**Strategic Infrastructure and
Planning
County Hall
New Road
Oxford
OX1 1ND**

19th May 2021

**Re: APP/C3105/W/21/3270400 - Land North East Of Fringford Study Centre
Adjoining, Rectory Lane, Fringford**

Figure 5: Development Proposals overlaid on "Plan 1: Survey Location with Magnetic and Resistivity Anomalies" In: 2000. Blinkhorn, P, Bloor, C and Thomason, D. Excavations at The Paddock, Rectory Lane, Project No.00001 | 21/2/2021 | Prepared By: ARTE-FACTS

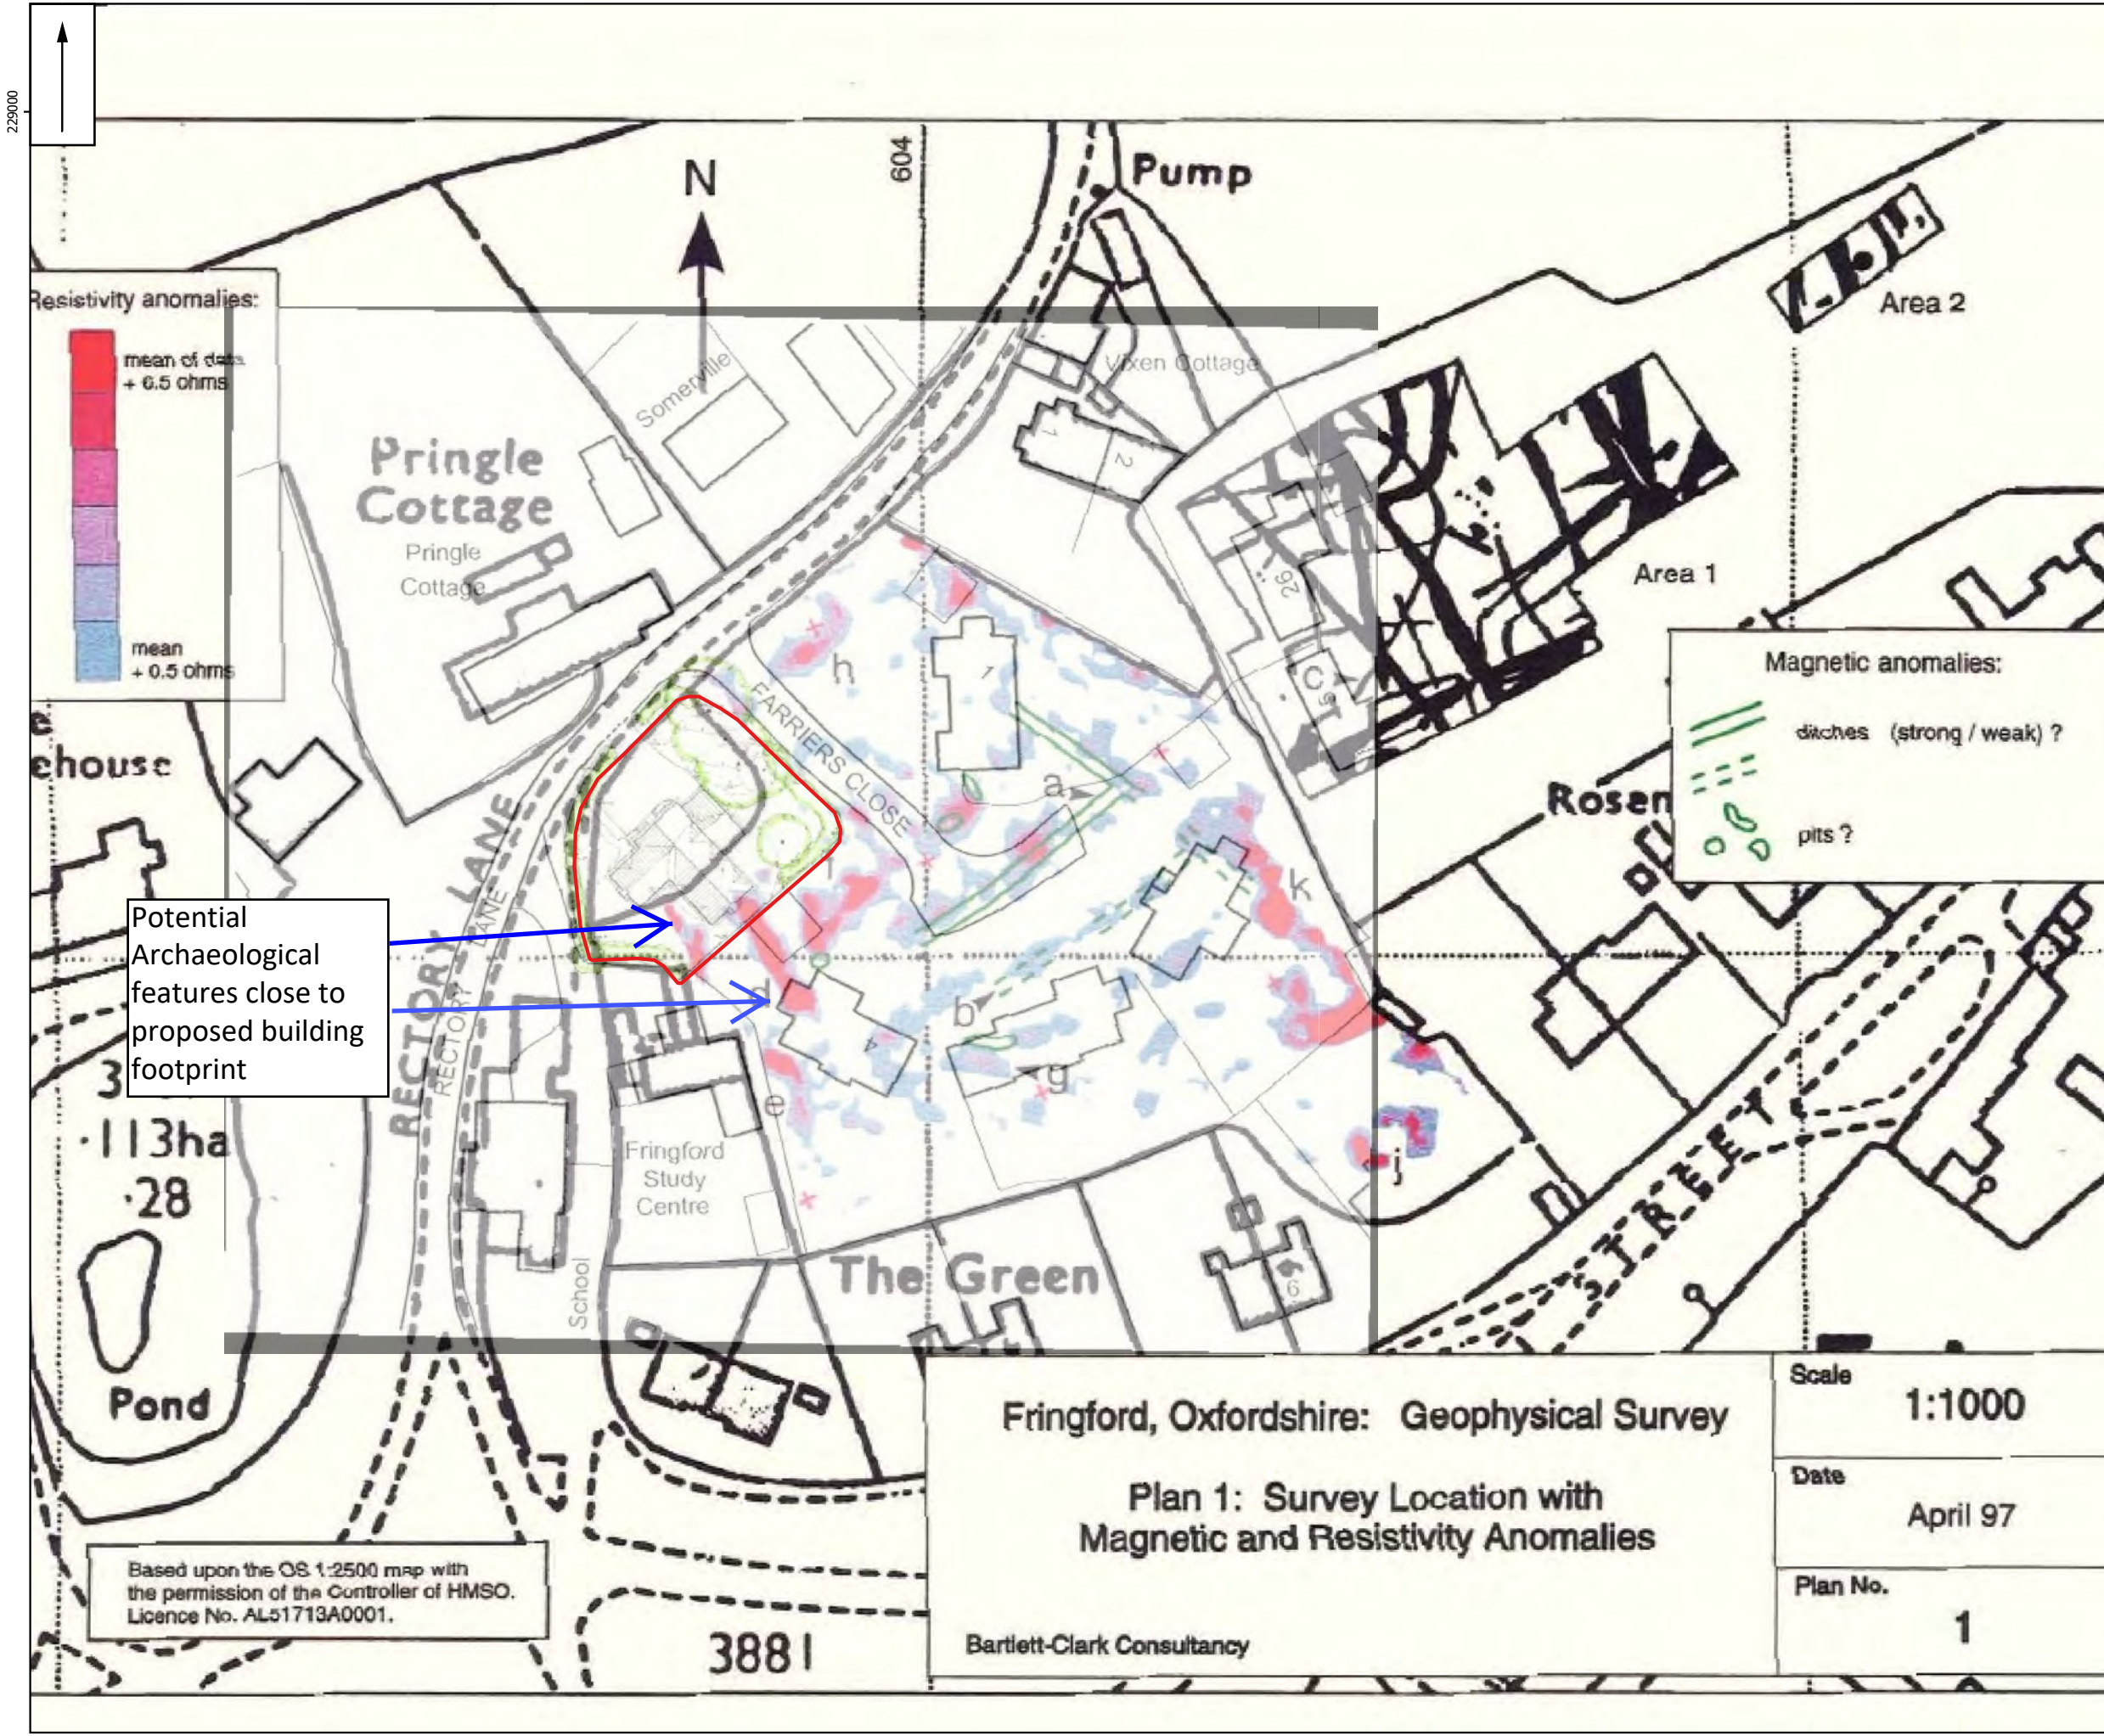
The assessment states that part of the site has been evaluated, but this is not the case although a very small part of the proposed development site was included on the north western edge of the geophysical survey. It should be noted however that the geophysical survey did not identify the location of the two medieval buildings later found within the main area of the survey and the conclusions of the geophysical survey report make no reference to the potential for stone buildings to survive on the site.

Even if this survey had included the whole of this proposed development plot then these results could not be relied upon on their own to identify the presence of further, well preserved, medieval buildings. No consideration of the veracity of this geophysical survey data has been included in the assessment.

Figure 6: Development Proposals overlaid on "Figure 7 Phase 4 and 4a. Early - middle 13th century" In: 2000. Blinkhorn, P, Bloor, C and Thomason, D. Excavations at The Paddock, Rectory Lane, Fringford 1997

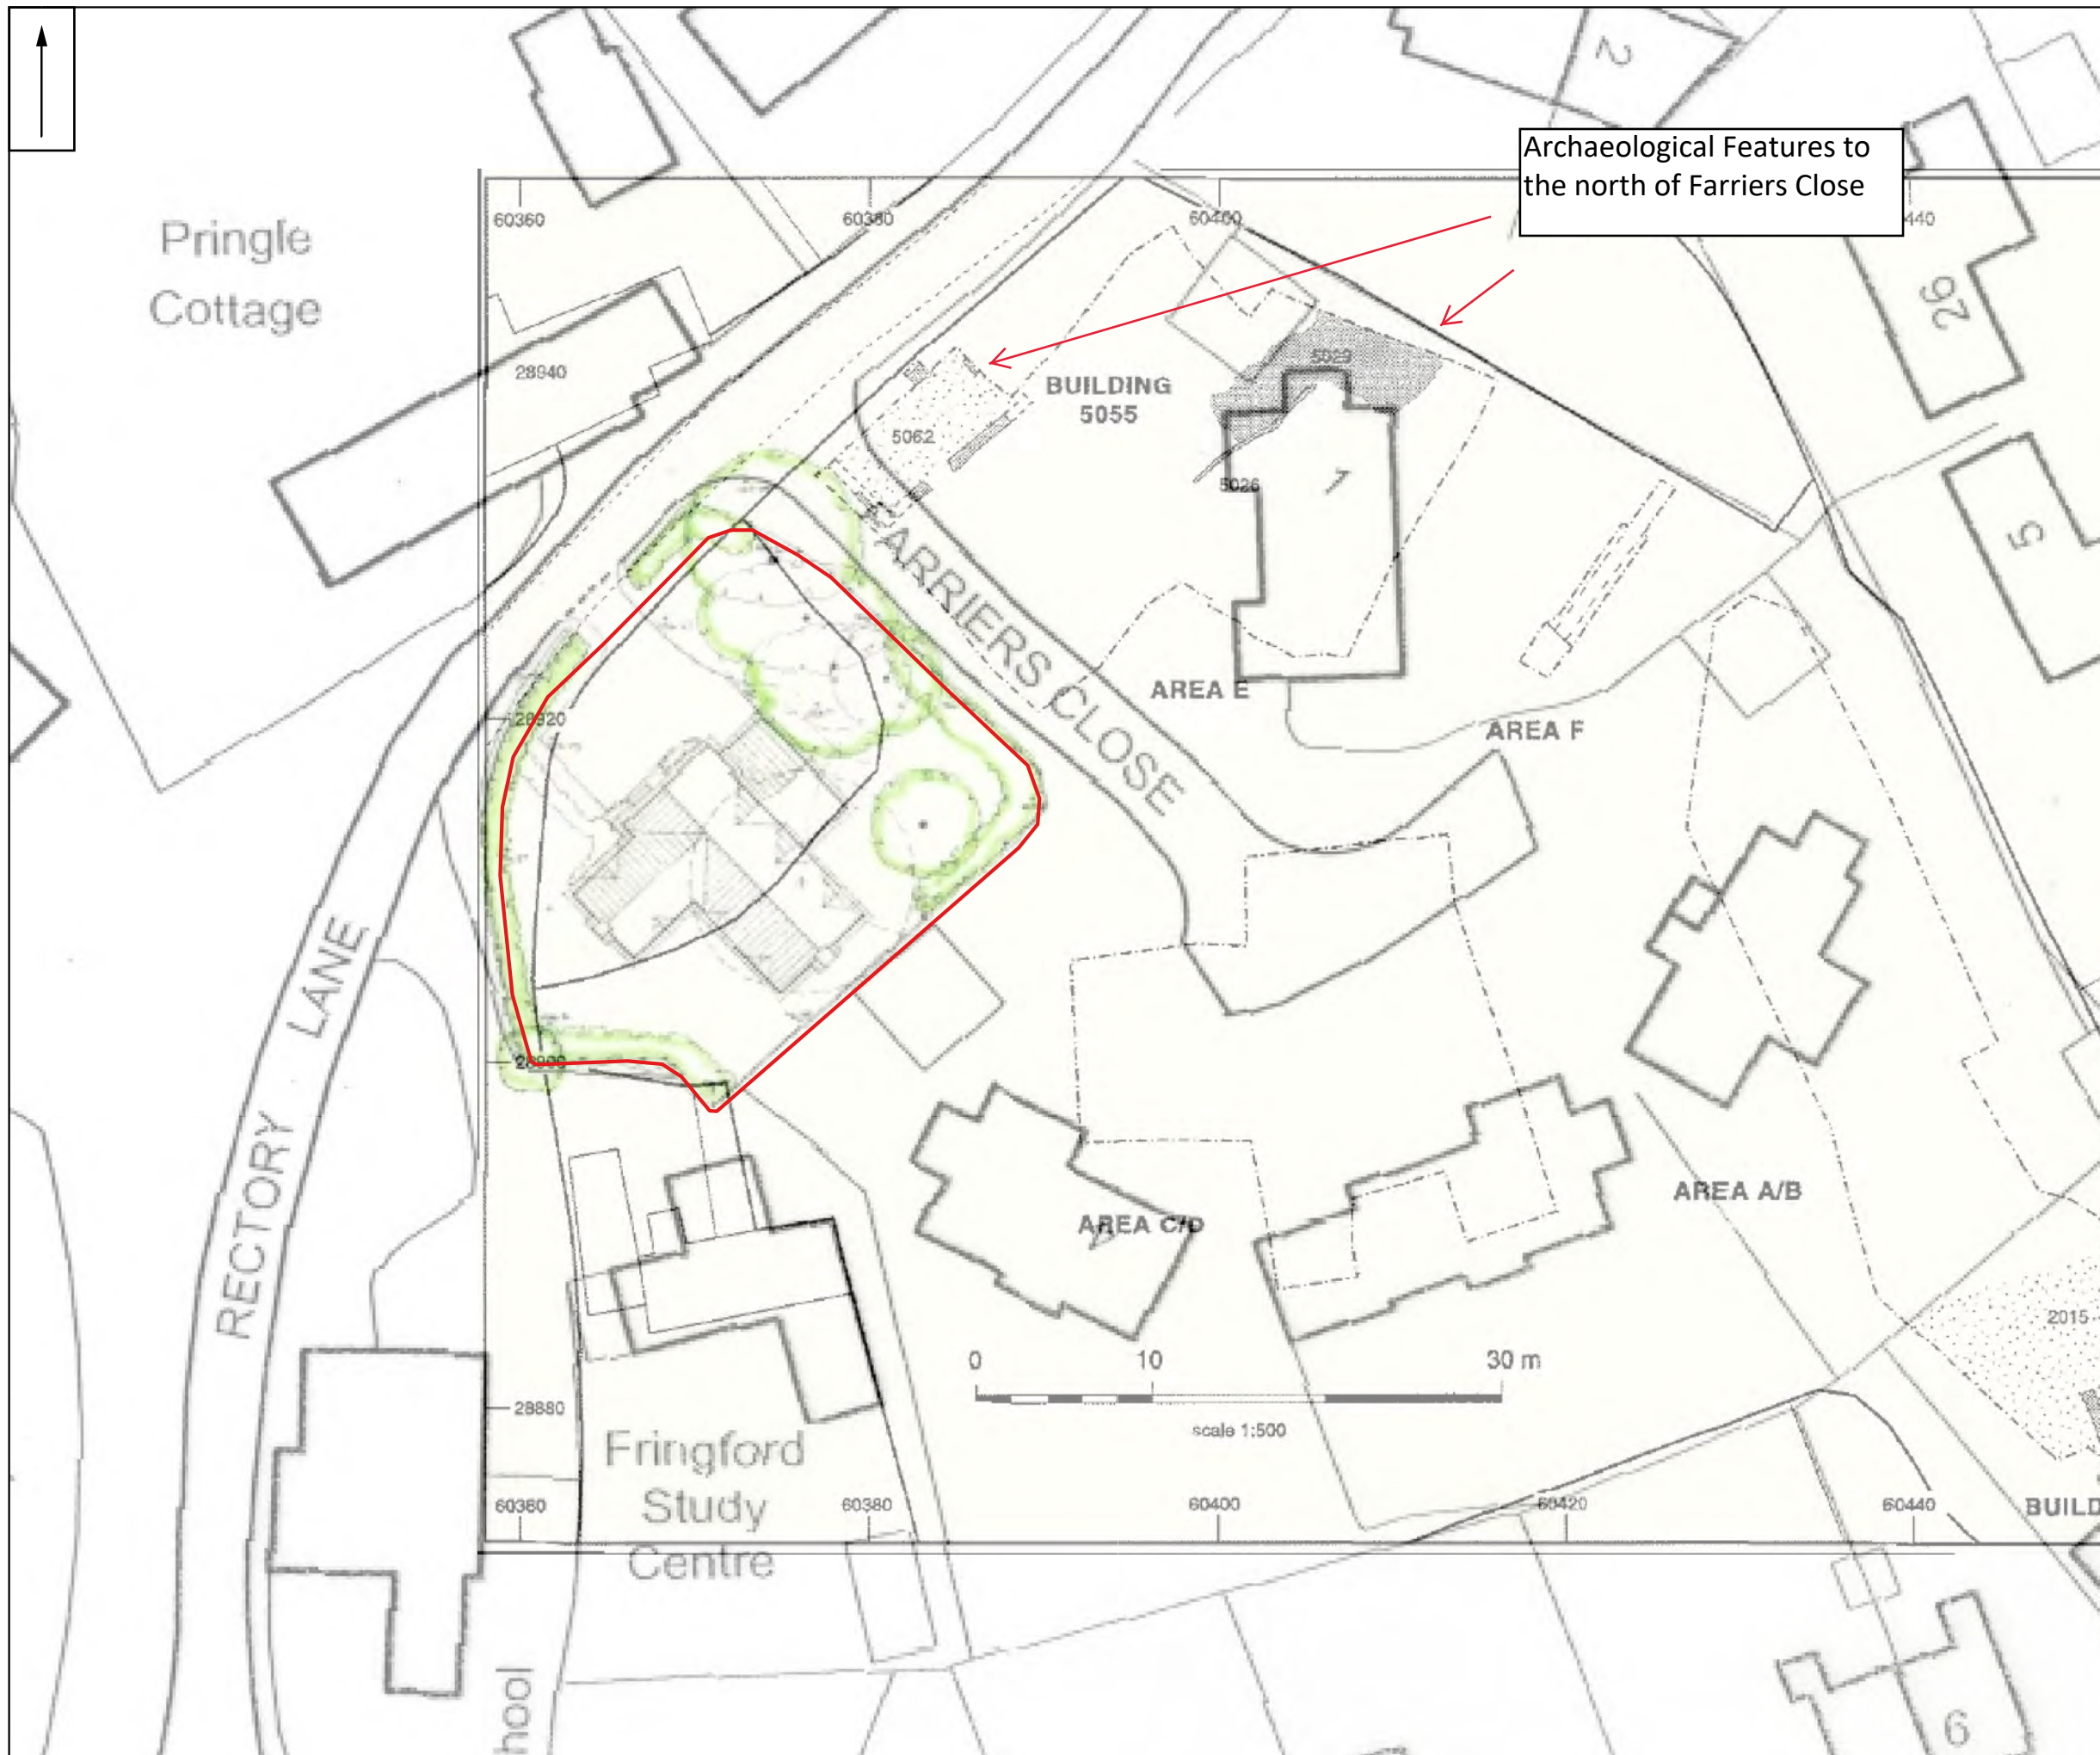
The assessment also assigned a medium potential for medieval deposits to be present. The mid C13th building recorded immediately adjacent to this site was considered to be a barn type structure and it is likely this was located along the line of the current road. This proposed development site is located on the bend of this road as it turns to the south and is therefore a key location for a medieval dwelling or farmhouse. The potential for further medieval structures to be present on this site must be therefore also be considered high.

A second building was also recorded to the SE and other yards surfaces and occupation horizons were also recorded. These buildings were well preserved and were considered to be outbuildings. The summary from the earlier excavation included in this assessment highlights how well these remains were preserved in relation to other medieval sites in
